Pearl Place Buildings 1 & 2

**Developer
Avesta Pearl Street One L.P.**

**ADDENDUM II
Attachment**

September 25, 2006

**A10.2**

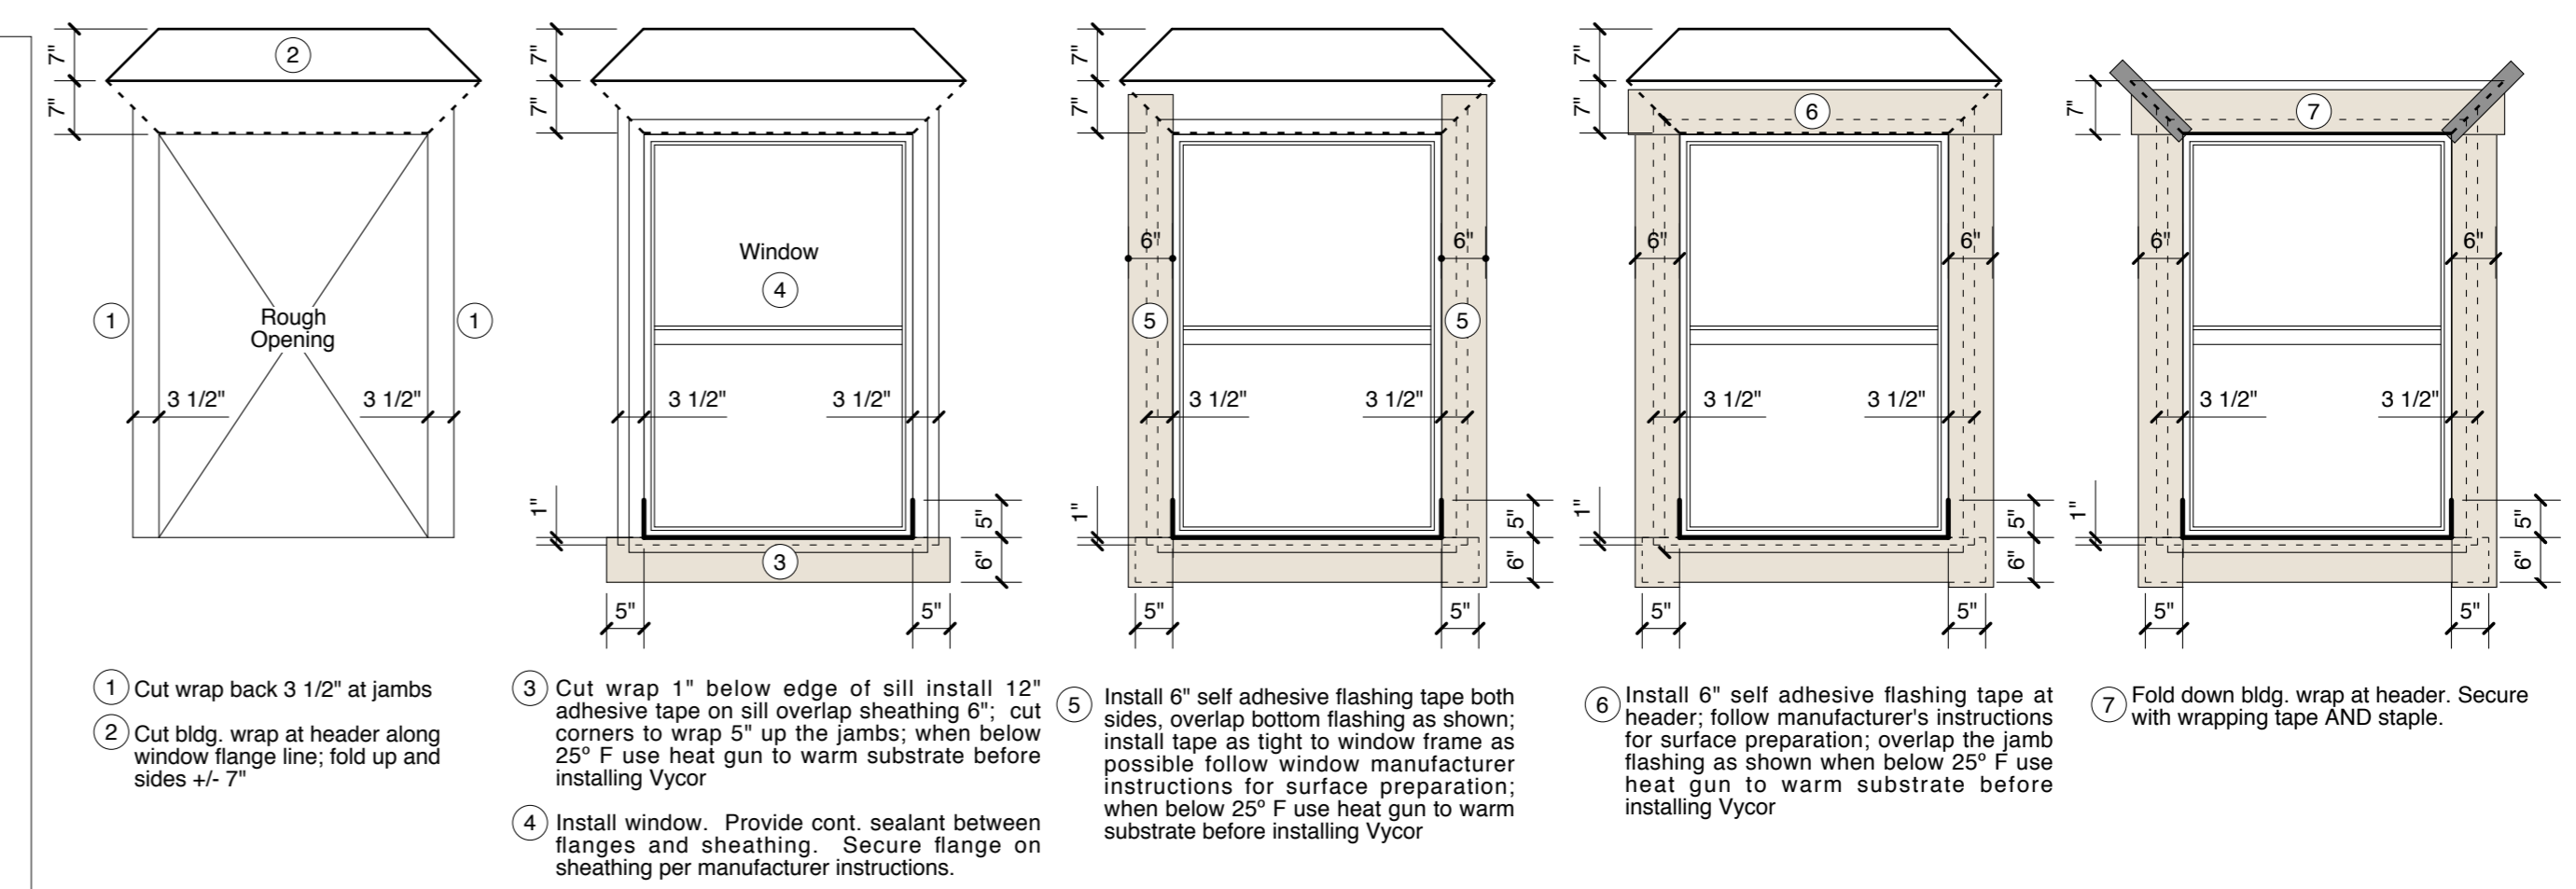
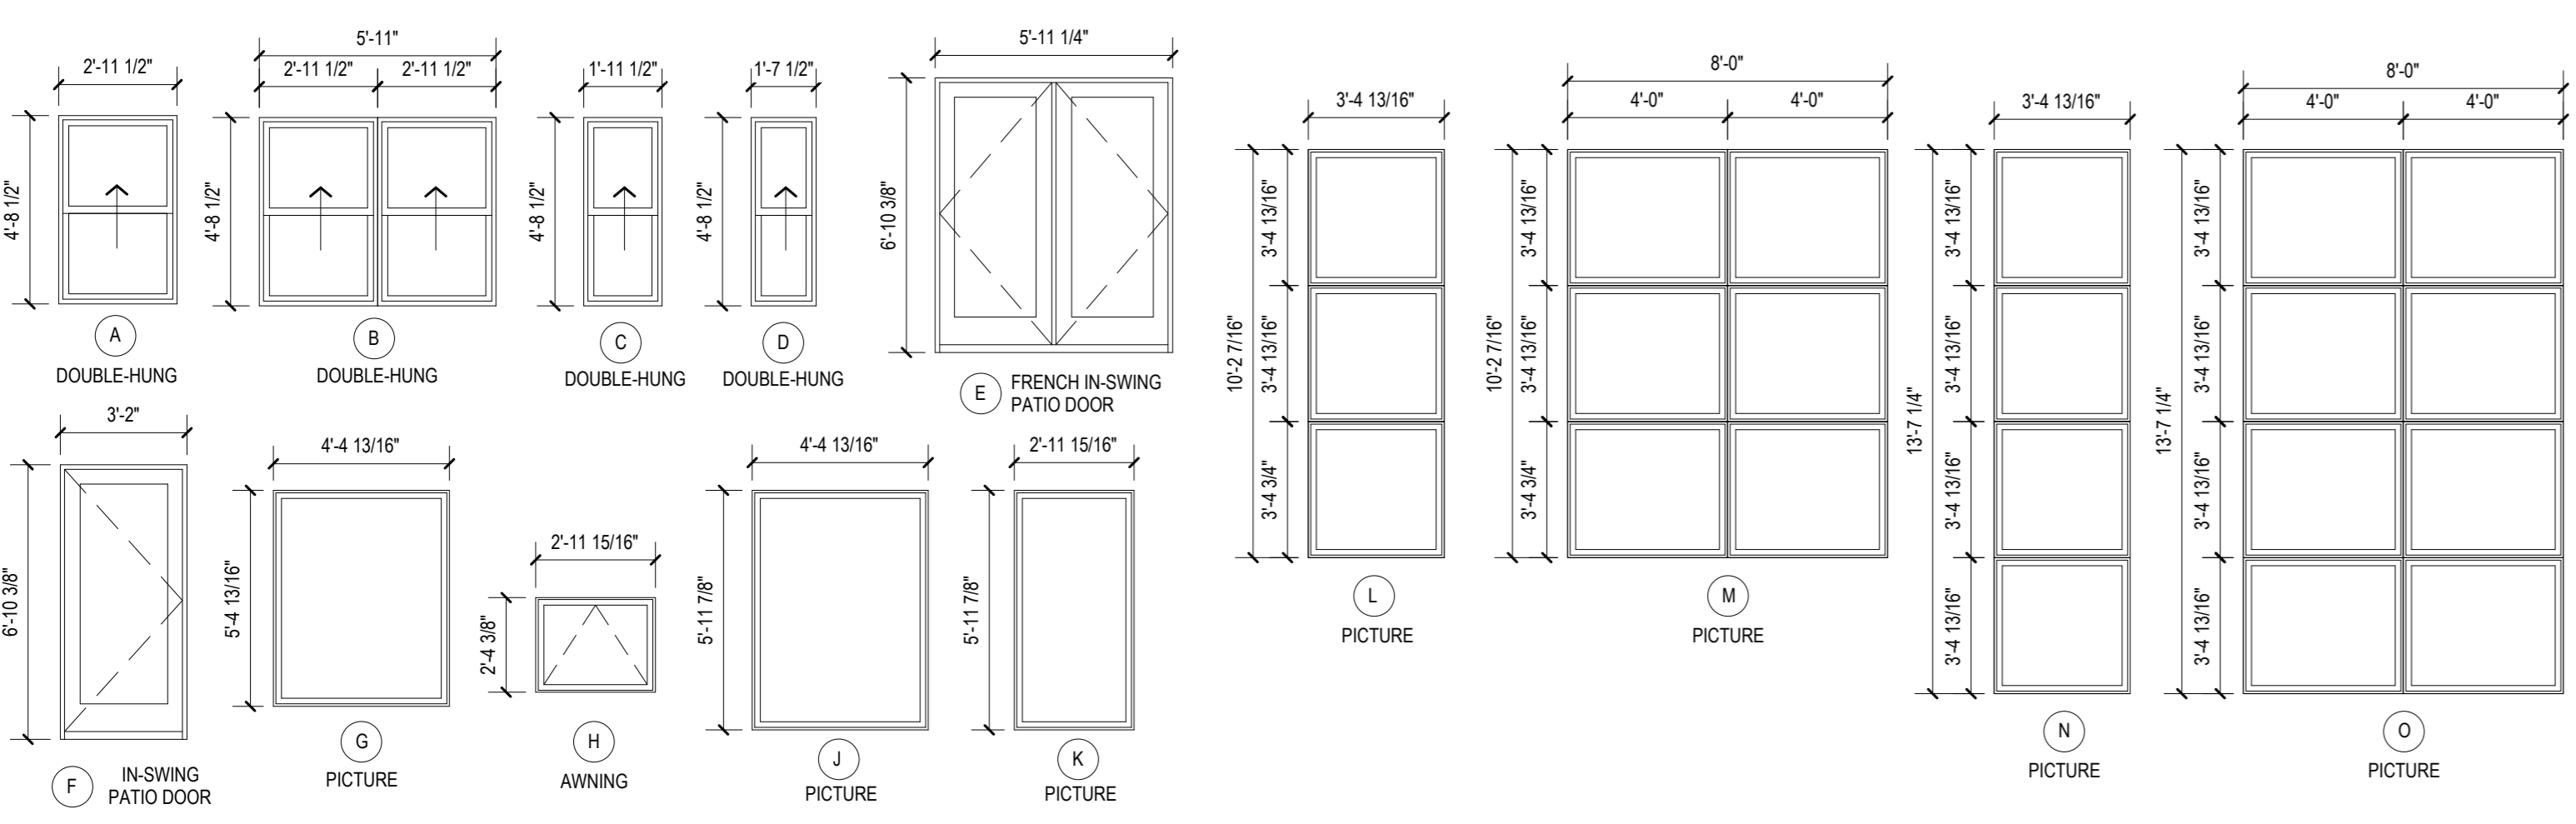
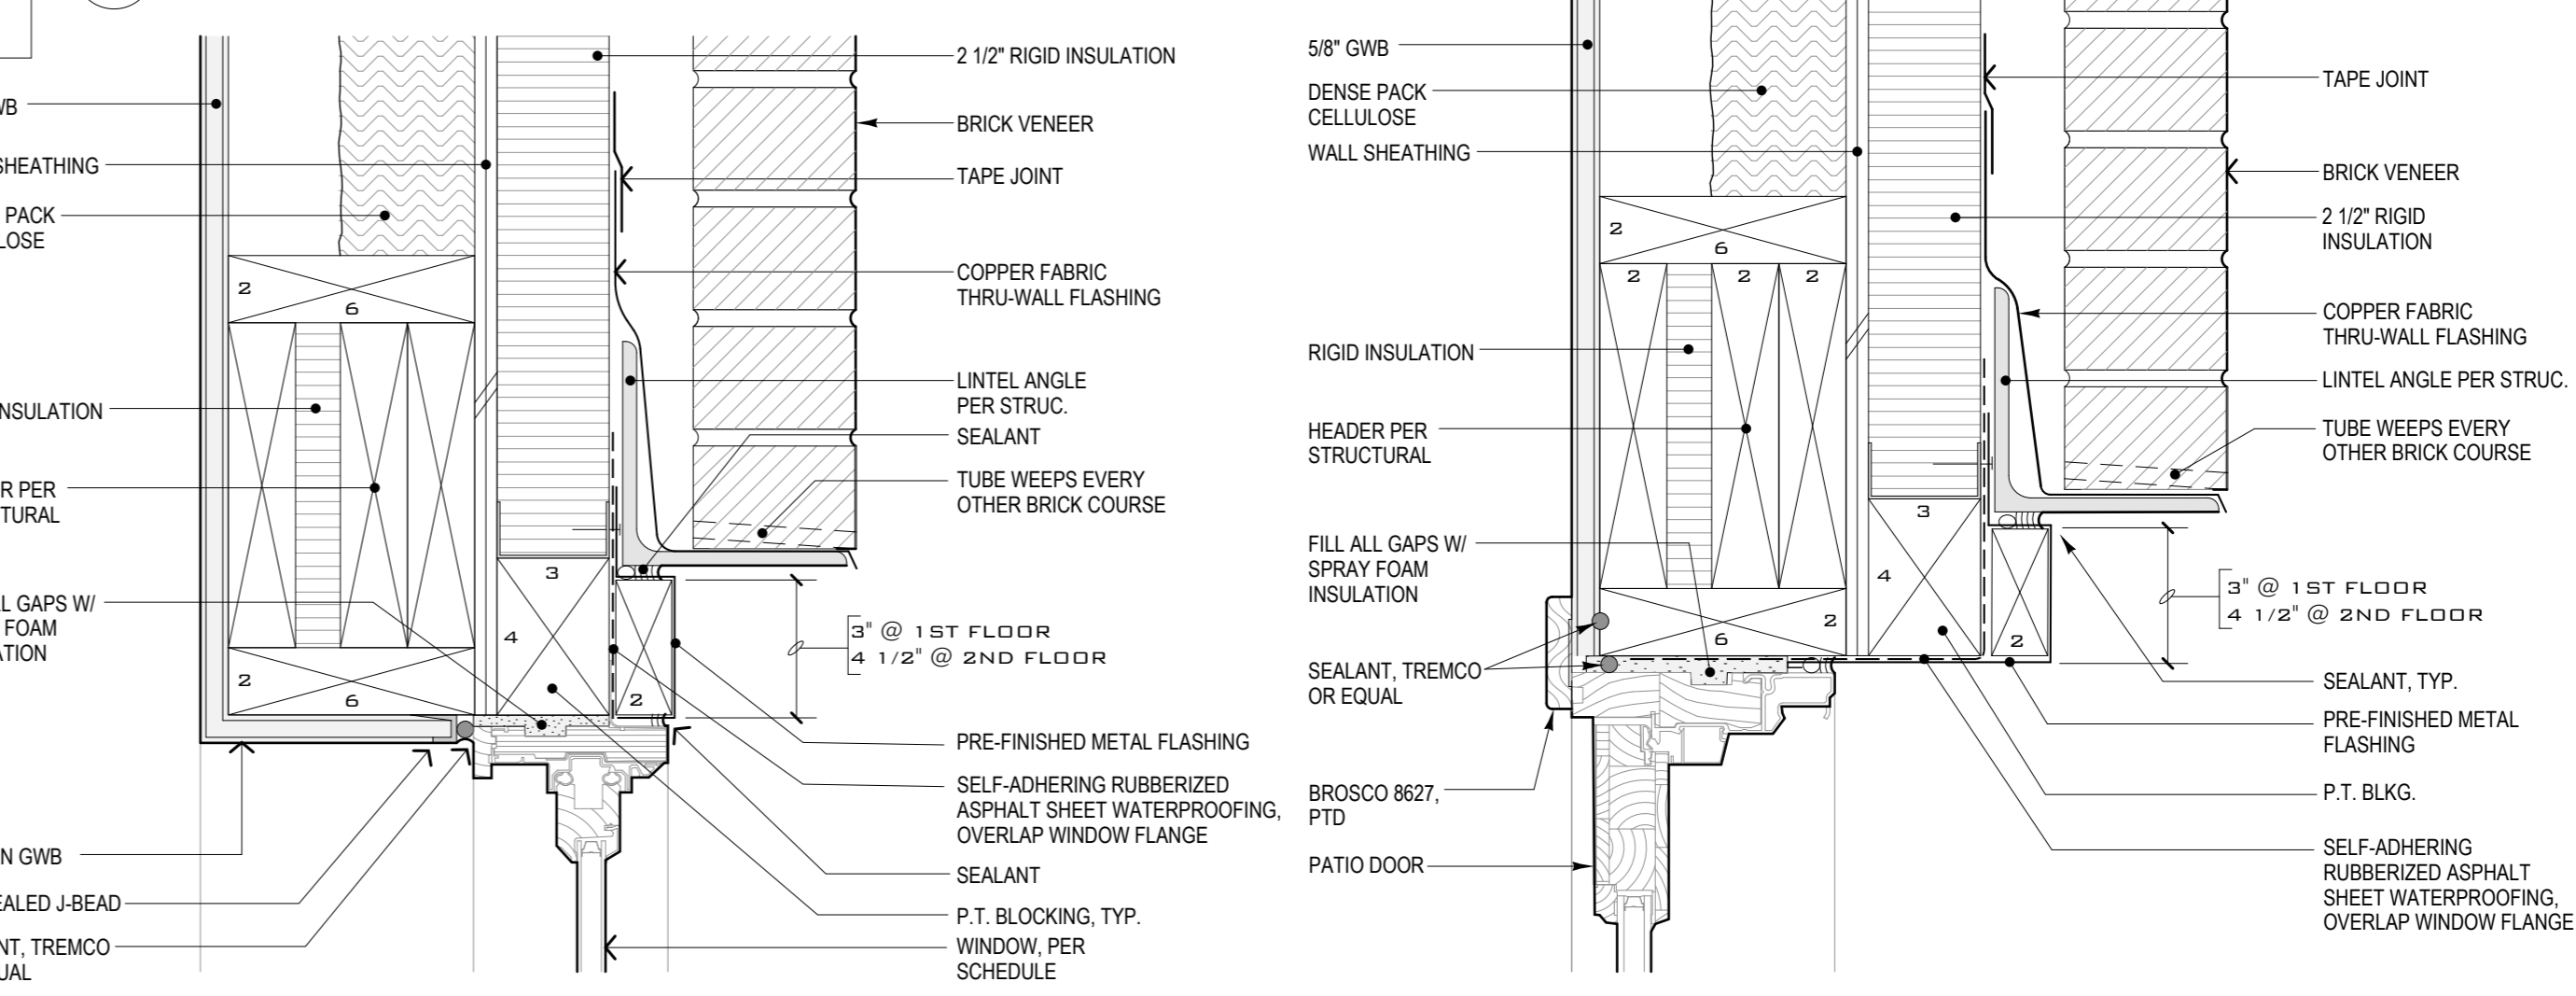
ALTERNATE 5: Delete windows W68, W70, W110, W112, W122, W124, W196, W194, W247, W249, W258, W260, W300, W302, W311, W313. Infill wall as shown on ASK8a. Change windows W111, W123, W248, W259, W301, W312 to wood clad per schedule shown on ASK 7.
